CITY OF ALBUQUERQUE

RE: **Lot 4 Block 11 Unit 5 Volcano Cliffs SAD 227**
6301 Casa Blanca NW
Grading and Drainage Plan
Engineers Stamp Date 12/10/19 (E10D070)
Pad Certification Date: None provided
CO date: 12/16/2020

Based upon the information provided in your submittal received 12/17/2020, this plan cannot be approved for CO until the following comments are addressed.

TITLE: 6301 CASA BLANCA NW
GRADING & DRAINAGE PLAN

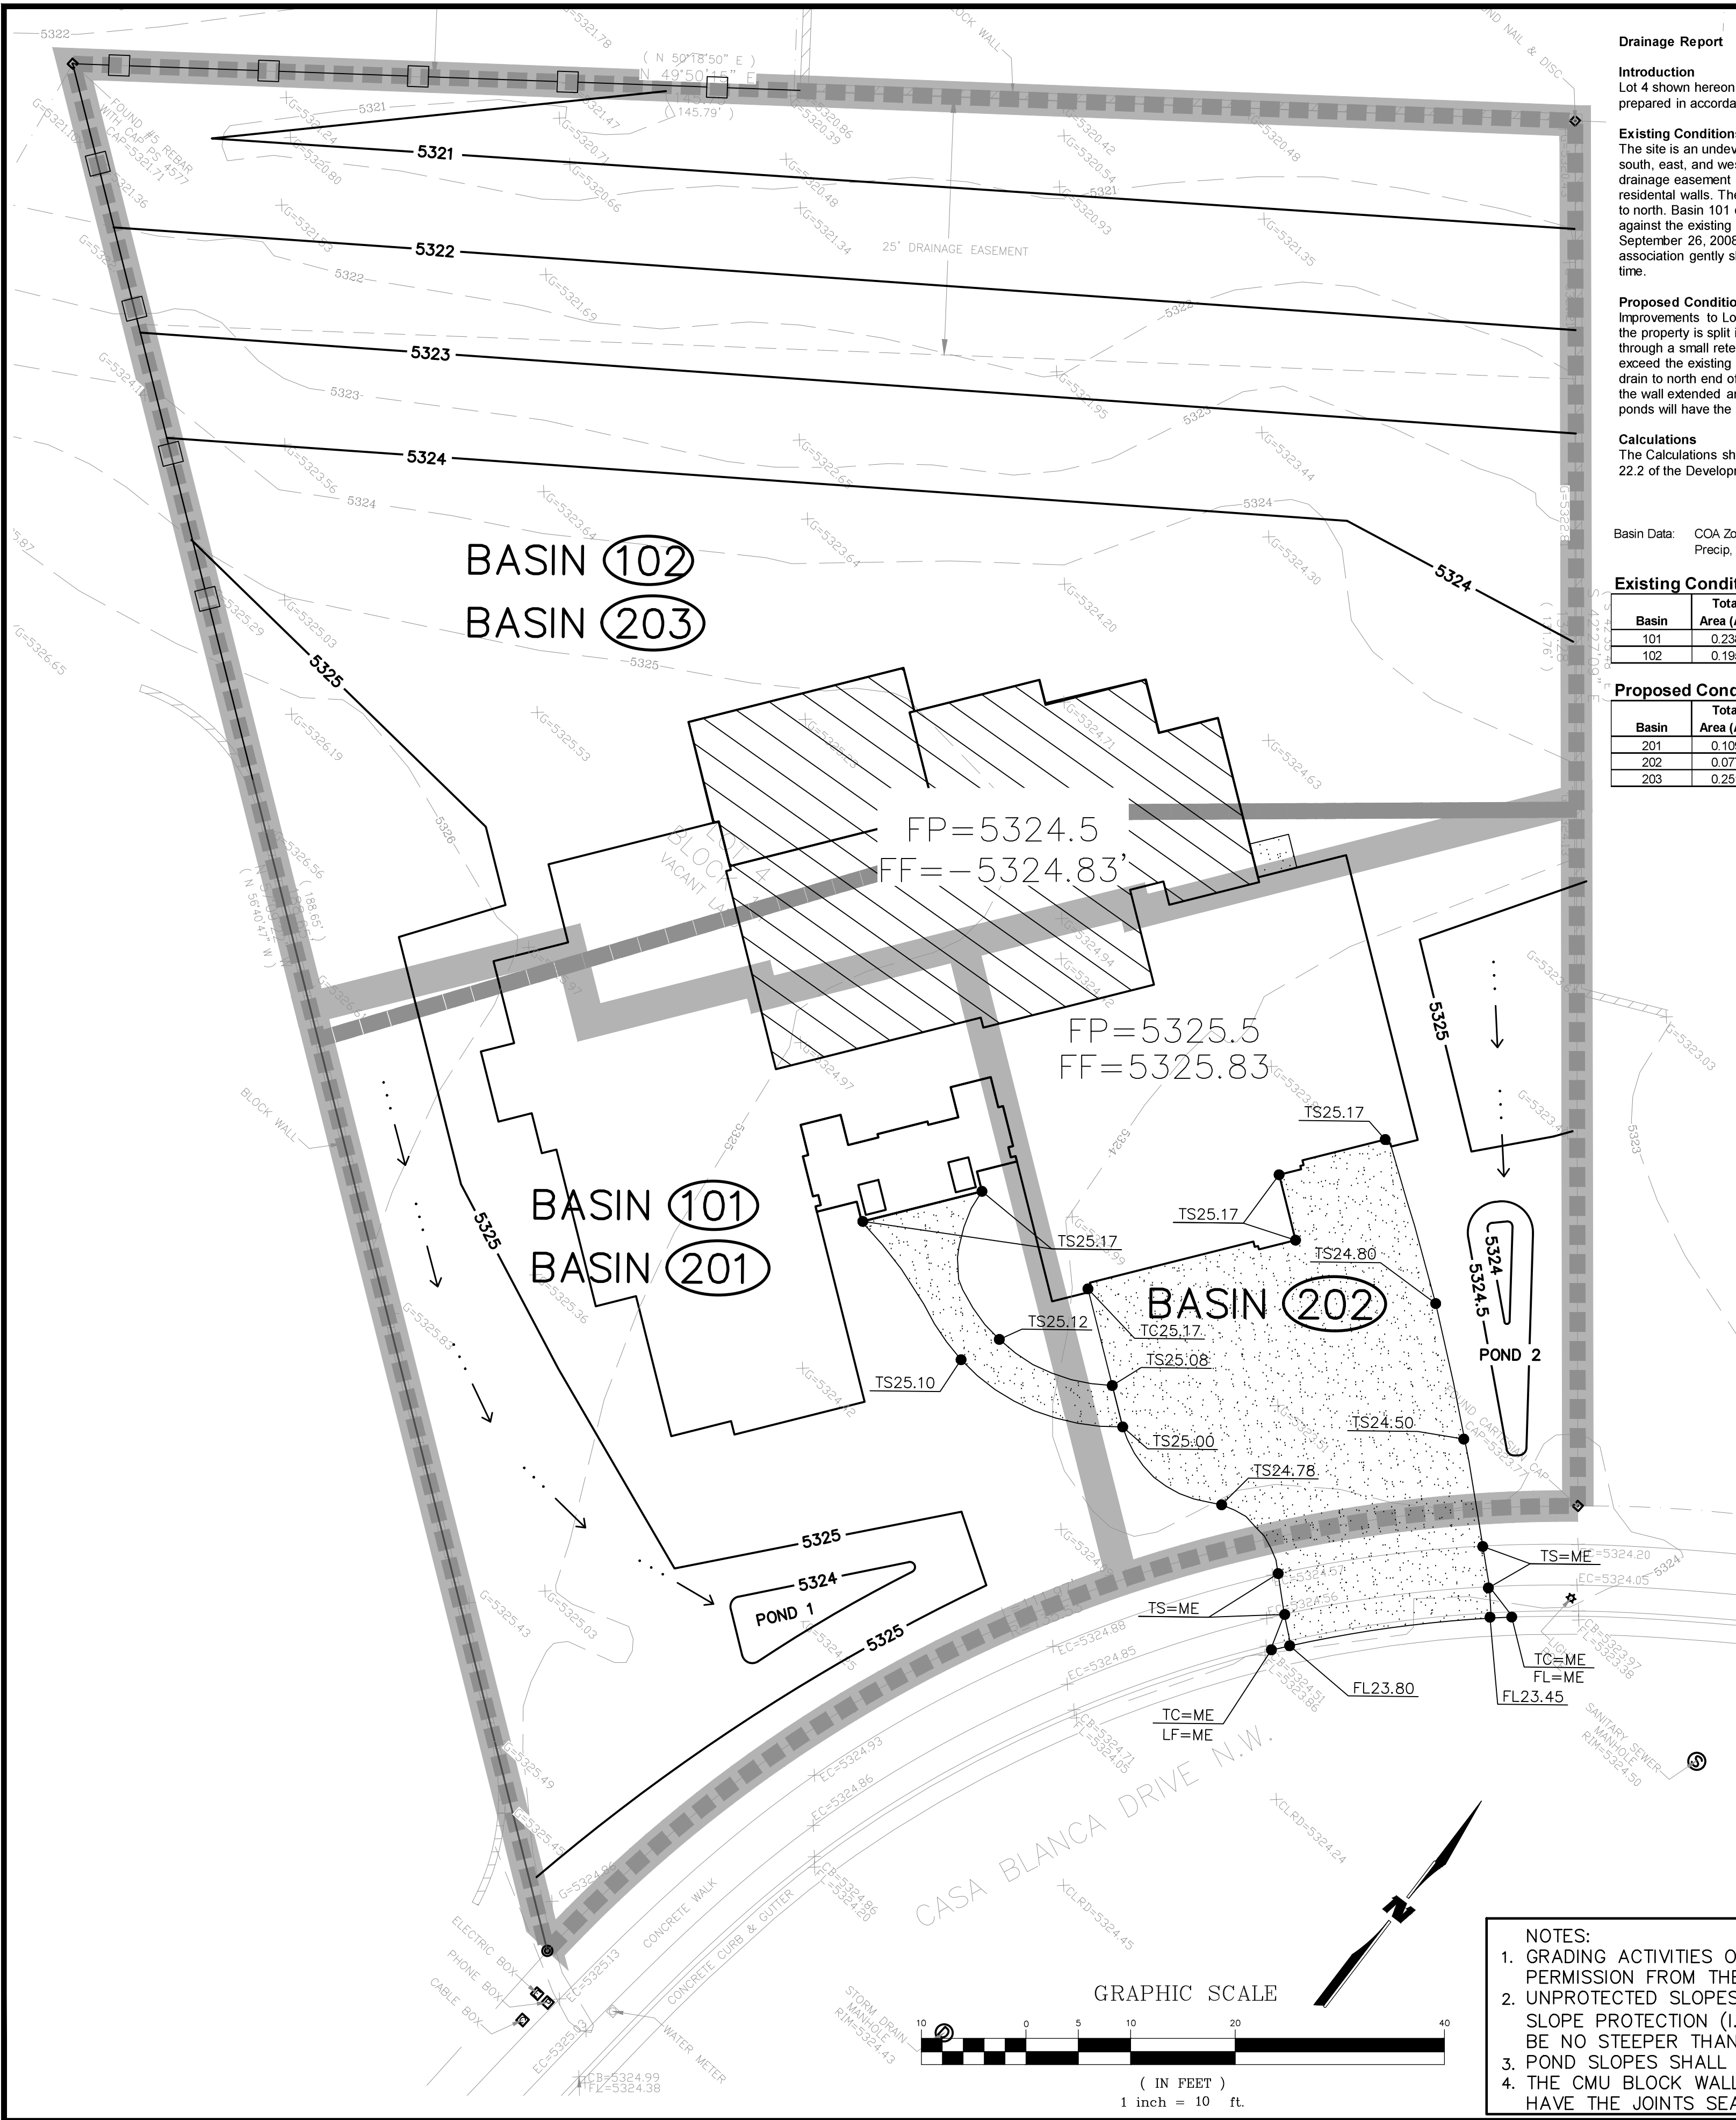
- Provide the size of pond in the rear yard.
- Adjust the land treatment values.
- Have the gravel swales in place.
- Have the drive pad in place.
- Provide the correct date in the CO language for the approved plan.
- Make sure all landscaping is in place which controls the drainage for this site.
